Application No: BN/142/21/PL
Site Address: 1 Como Barnham Road Eastergate PO20 3RT
Description of works: Erection of a new two-storey building to contain 2 No 2 bedroom flats with associated parking, bin and bike stores and landscaping. This site is in CIL Zone 2 and is CIL Liable as new flats.

Thank you for your internet representation made on 7th December 2021 which has been recorded as an objection with the comments as follows:

Site Block Plan (1:500)

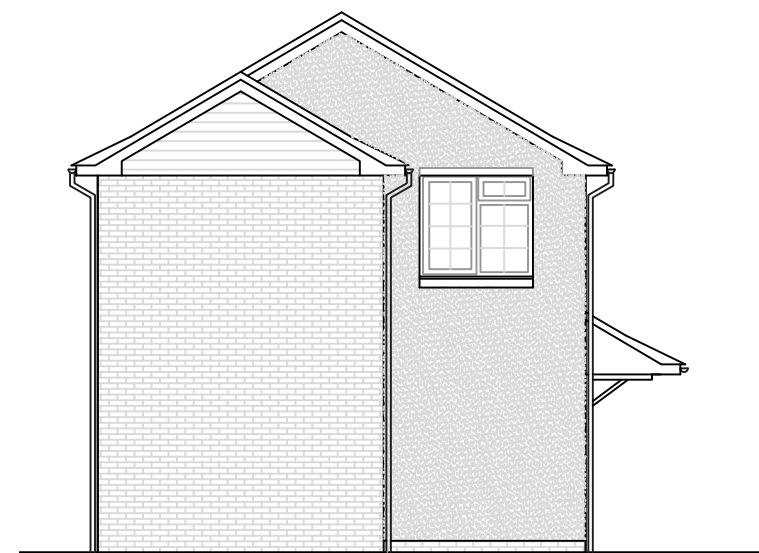
The proposed development would result in an over development and over intensification of the site, with a site layout that is incongruous to the surrounding street pattern on the northern side of Barnham Road.

The siting and scale of the proposed building, detached from the existing, would give it a somewhat alien appearance, invasive to the street scene, particularly from the private road that runs parallel to the site.

Elevations (1:100)

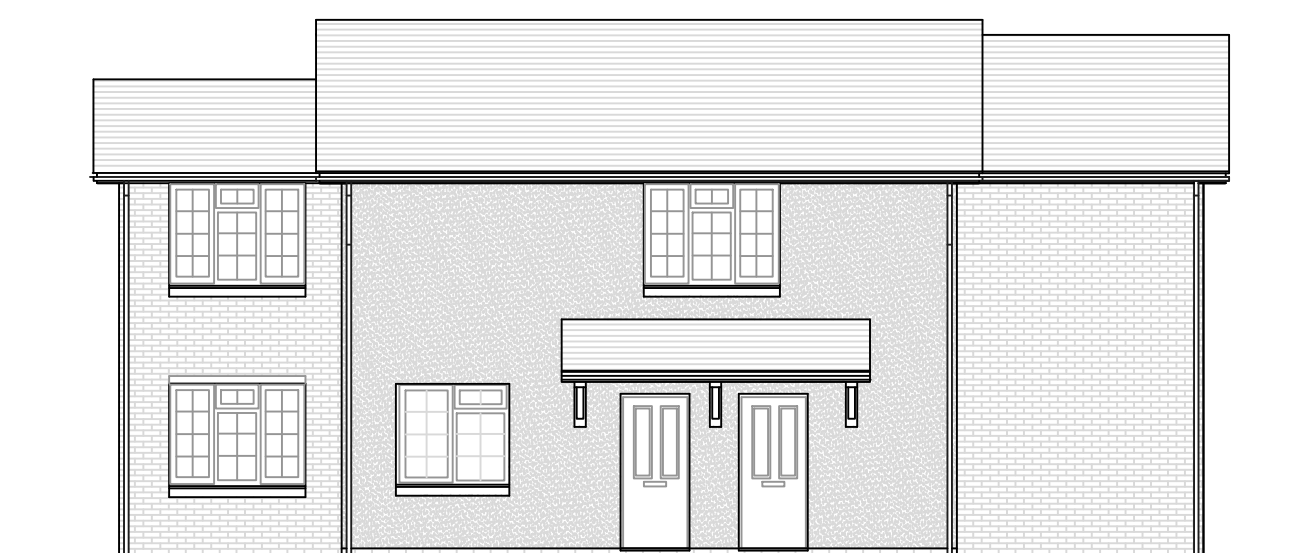
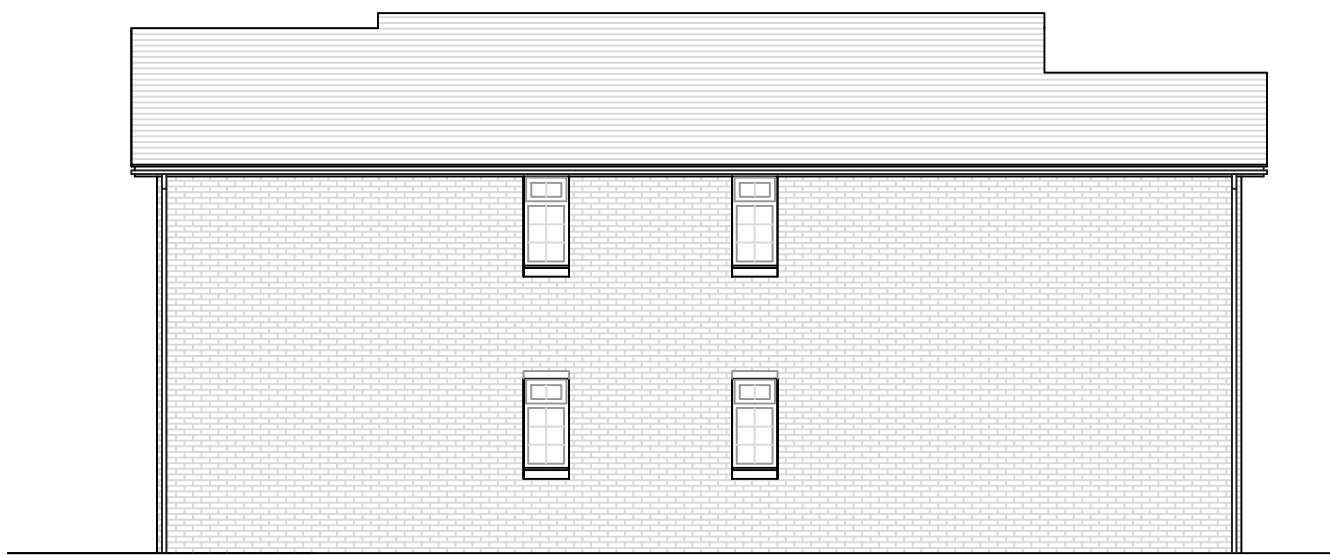
The windows on both side elevations would overlook the private amenity areas of the neighbouring dwellings, especially no.18 Hall Cottages and the Mowhay.
